Your Ref: OWPC18865
Our Ref: A/8/18/PL 26-01-2018
Please ask for:
Mrs A Gardner

Variation of condition 2 imposed under A/173/16/PL to read 'the development to be carried out in accordance with the following approved plans ADC 962/04 REVA, ADC962/13 & ADC962/14 relating to slight repositioning & change in size of building, revised position of rooflights on east, north & south elevations. This application affects the character & appearance of the Angmering Conservation Area.

Land Rear of 1 To 6 The Cottrells Angmering

A		Layout amended		10.11.17	
Rev		Description		Date	
Job Reference		Client			
New House The Cottrells Angmering, BN16 4AF		AM Homes Ltd			
Drawing Title		Drawing No		Rev	
Ground Floor Plan		ADC962/04		A	
Date	Scale	Dwg Size	Plot Style	Drawn	Checked
24.04.17	1:100	A3	ADC-red	TGS	AD

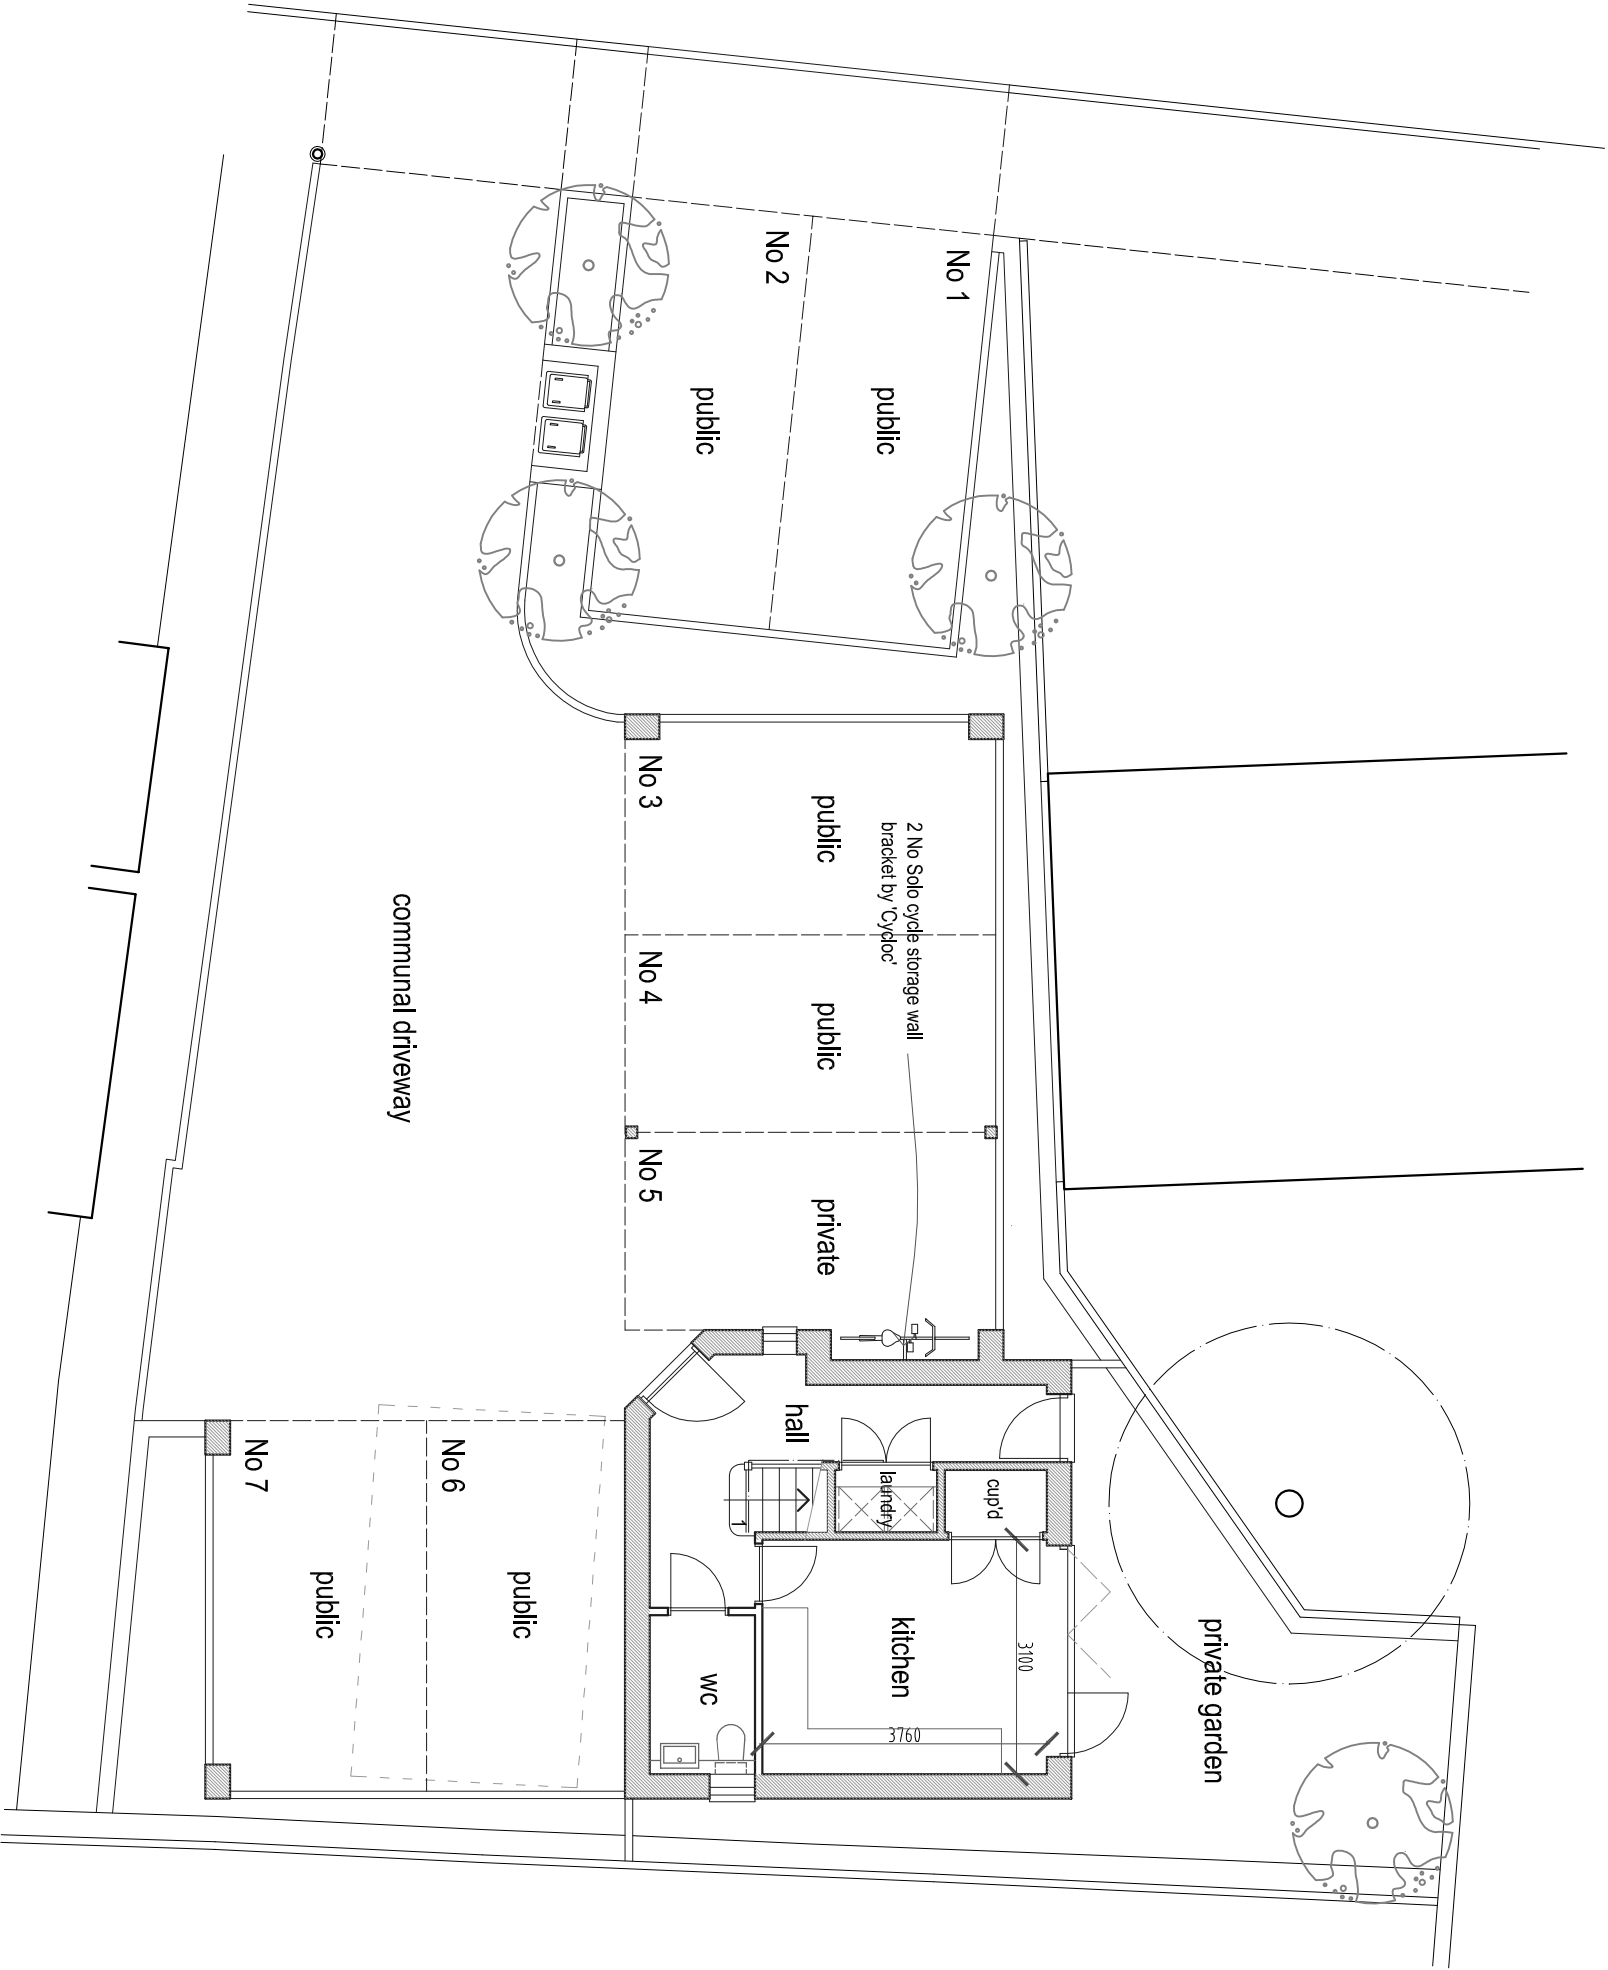
As has been shown in other correspondence, the kitchen is not installed downstairs as per the plans. Instead the room has been fitted with an en-suite shower facility and will therefore be assumed by anyone viewing the property to be a 3rd bedroom. This is in contradiction to Condition 3 in the officers report that was presented at the Council Meeting on 6 June. The development is only approved as a two bedroom residence, as the Officer correctly notes any increase in the intensity of use of the development will have an adverse effect on the adjoining residential properties particularly with regard to parking which is also stretched beyond capacity.

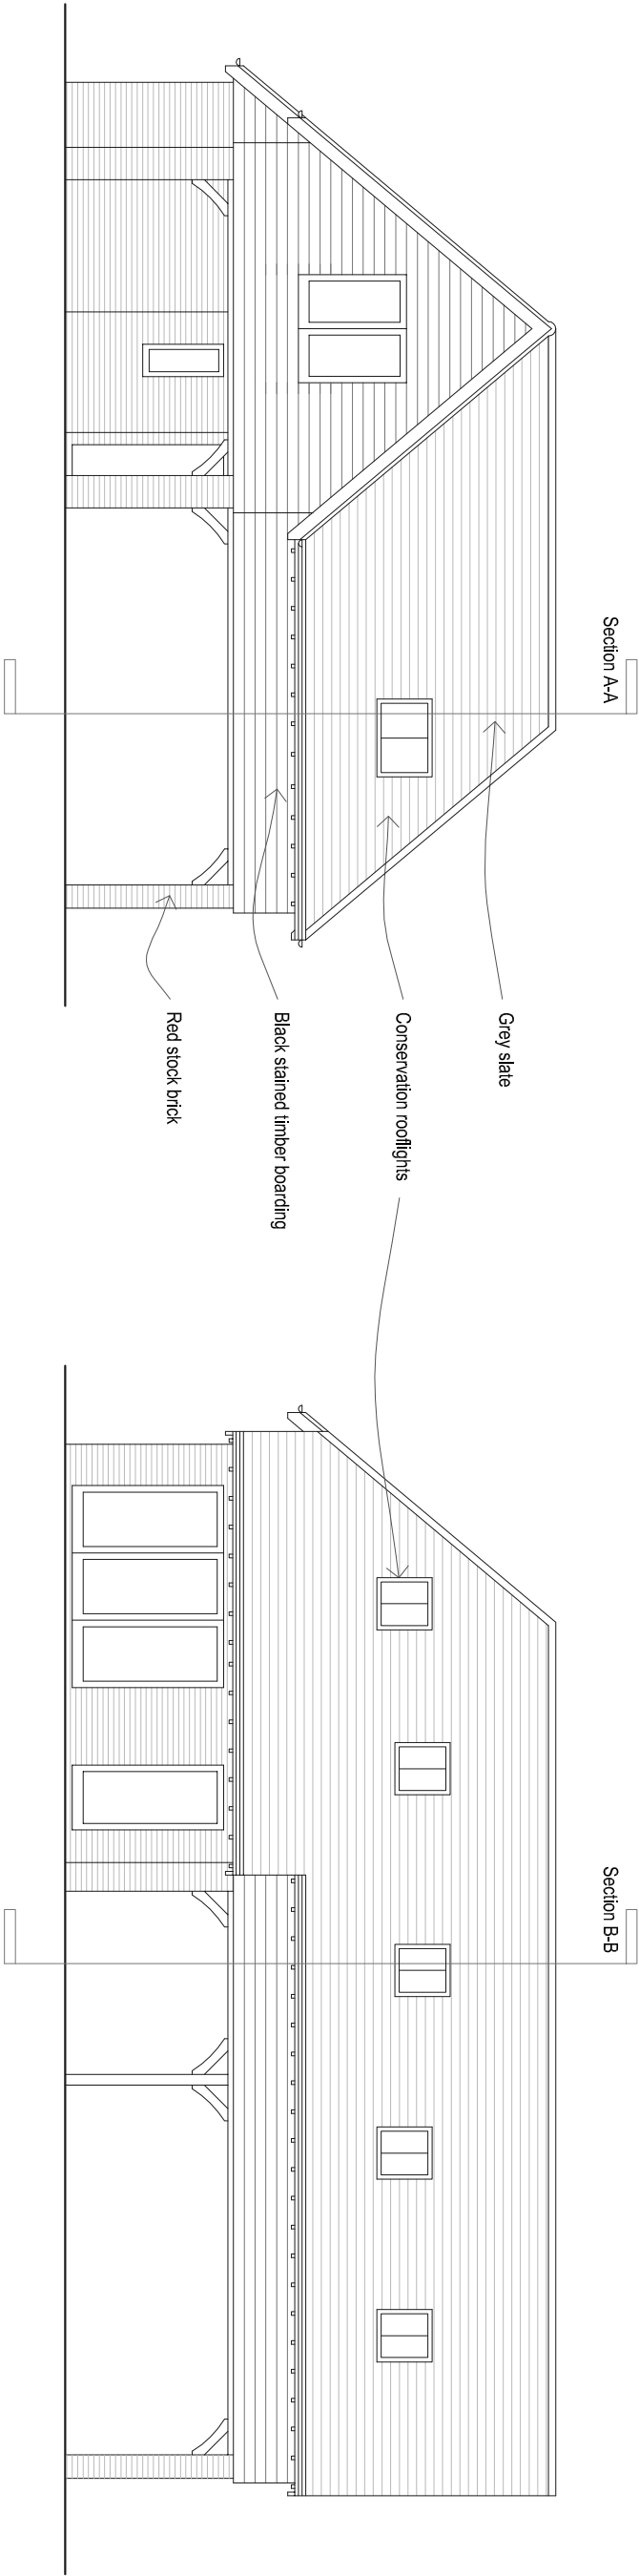
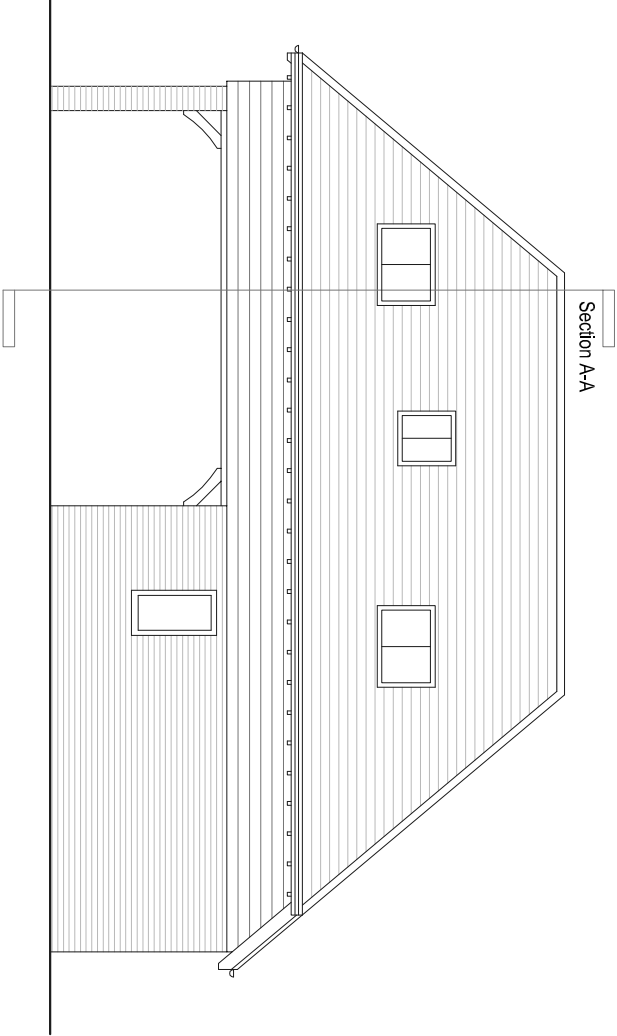
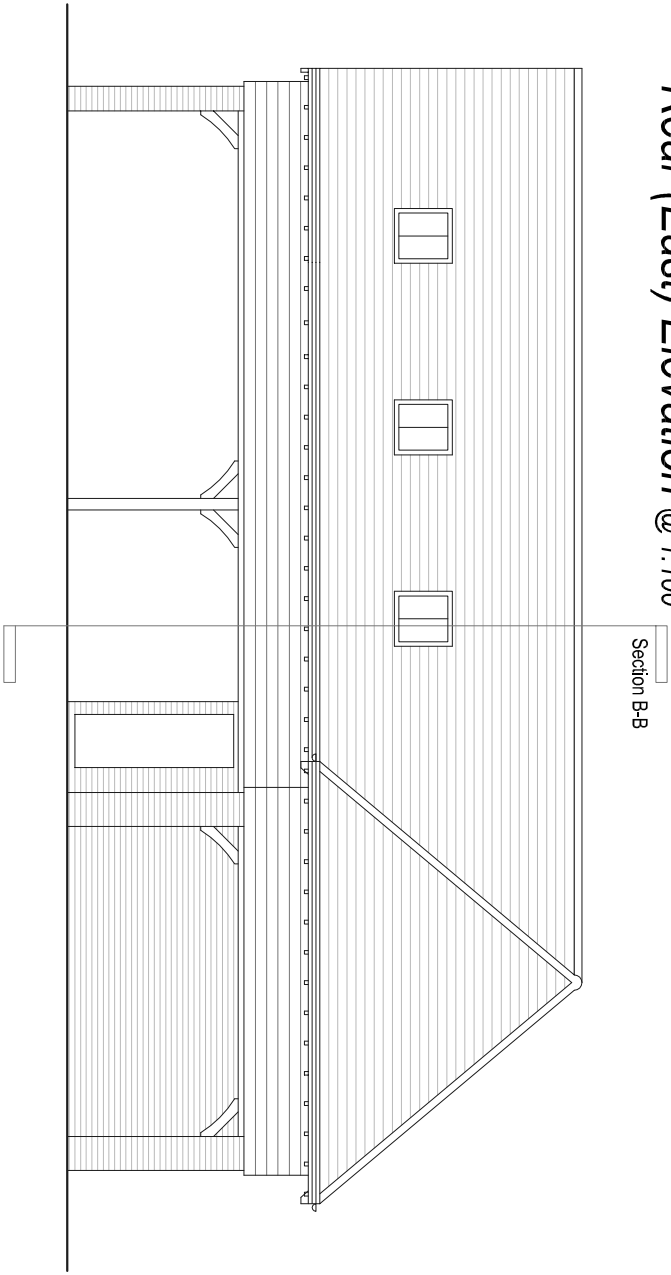
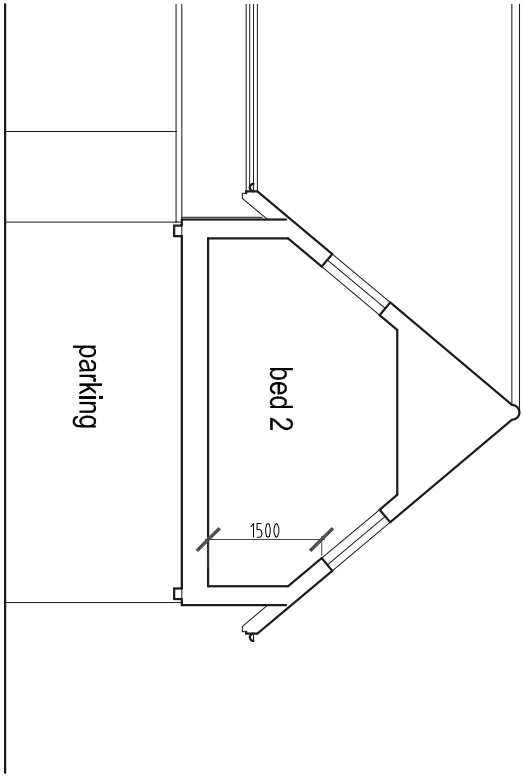
With regard to the repositioning of the windows I object to the size and position of these as they provide a direct view into the adjoining properties. They are not as represented on the original approved plans and increase the negative impact of this overbearing development.
